Charlotte Department of Transportation

Memorandum

Subject: Rezoning Petition 08-056: Located on the southwest corner of Nations Ford Road and West Tyvola Road (revised 5/19/08)

**TYVOLA APARTMENTS**  
**REZONING PETITION NUMBER 2008-056**  
 HATHAWAY DEVELOPMENT  
 TECHNICAL SITE PLAN

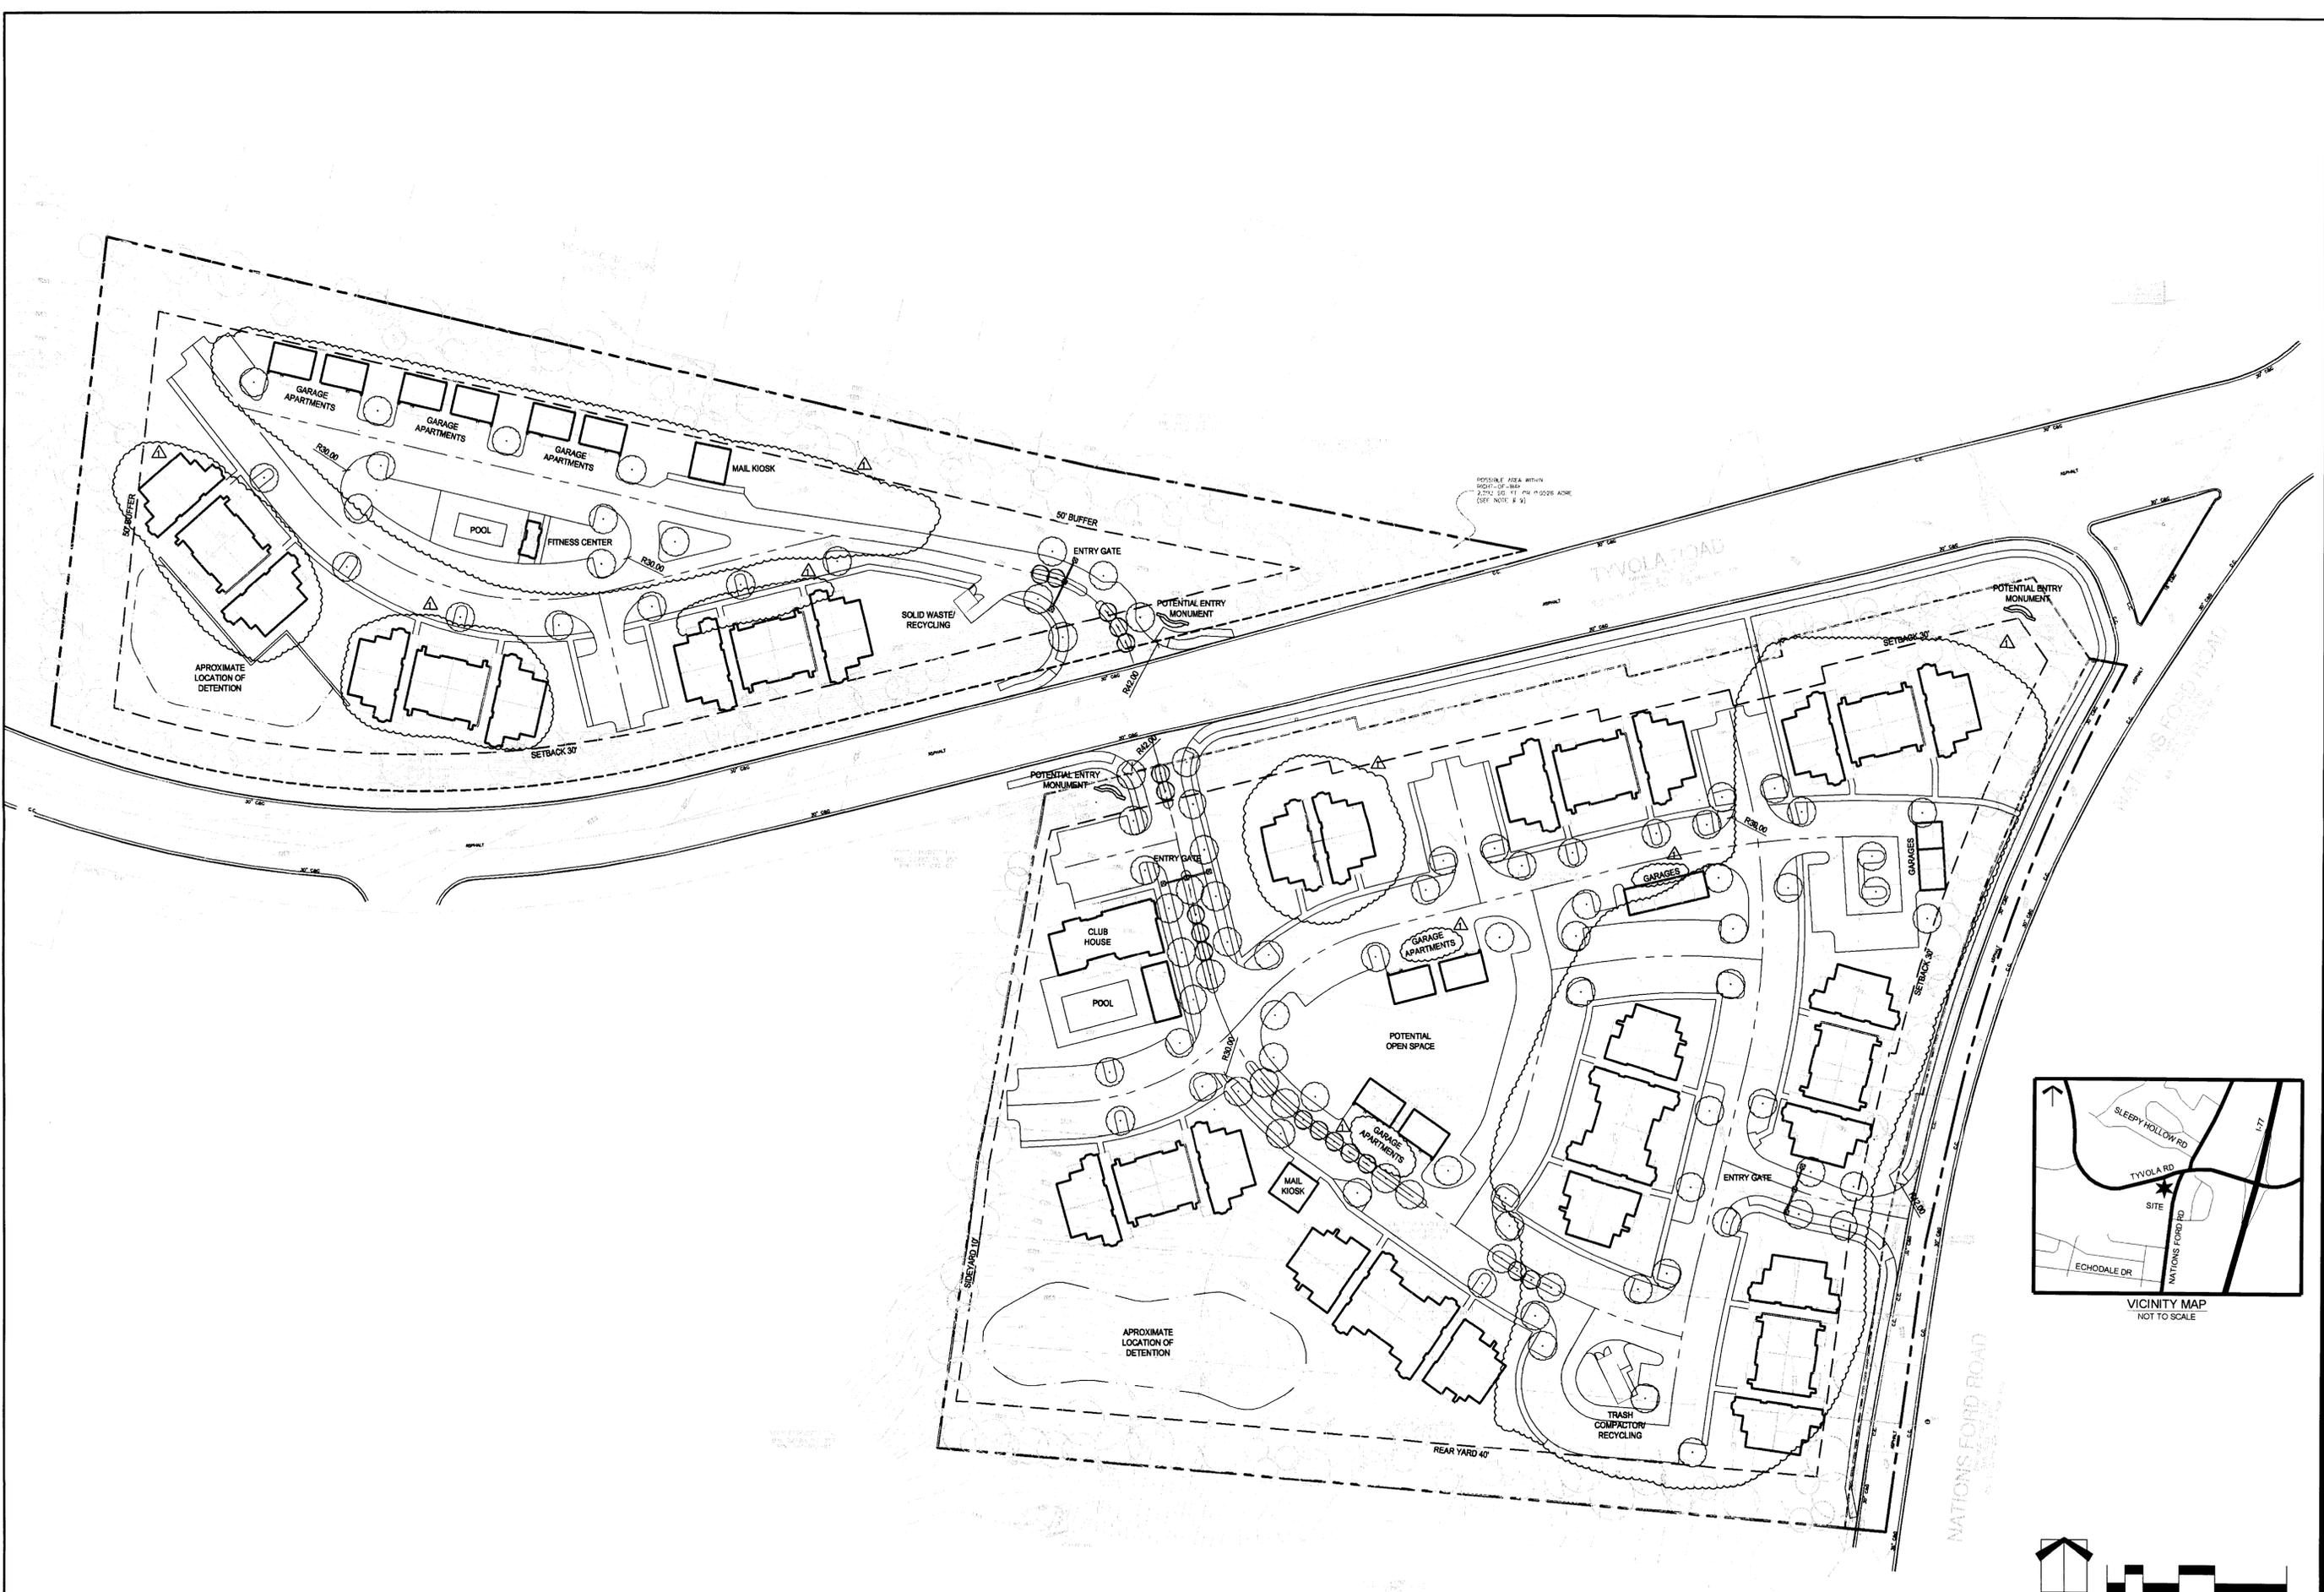
1. Left-turns into the proposed driveways cannot be made safely due to the left-turn offset/conflicts. For this reason, CDOT has determined that left-turn lanes on West Tyvola Road (both eastbound and westbound directions) and Nations Ford Road are necessary to serve the traffic using the proposed private driveway connections for this site. Full access/left-turn lanes at the Tyvola Road driveway is conditioned on comment 3 below. On West Tyvola Road it appears that the left-turn lanes may be able to be provided by restriping the existing painted out median area. The engineering design and construction of the left-turn lanes are the responsibility of the owner and shall be performed by a professional engineer

registered in the State of North Carolina who has roadway design experience. The design of left-turn lanes need to comply with NCDOT design guidelines with a minimum of 150 feet of storage and will be reviewed during subsequent permitting processes. (*Previous comment – 2nd time*)

If the left turn lanes cannot be constructed to meet minimum standards and to not impact the existing/adjacent left turn lanes, then access to the site will be restricted to right-in/right-out. This would require the petitioner to construct a concrete median to physically restrict access.

2. The site plan needs to show 6-foot sidewalks and 8-foot planting strips along both West Tyvola and Nations Ford Roads, as measured from any future curb line. CDOT will determine the location of any proposed curblines during the building/driveway permit process. (*Previous comment- 2nd time*)
3. A full-movement access is proposed on West Tyvola Road. CDOT will evaluate the location and configuration of the access and the gated entry location during subsequent review processes. Full-movement may not be feasible at the proposed location. (*Previous comment*)
4. Stubs from the multifamily component to the adjacent multifamily parcels to the west and south need to be provided for site inter-connectivity. A stub needs to be provided to the residential property to the west of the proposed northern multifamily site. (*Previous comment*)
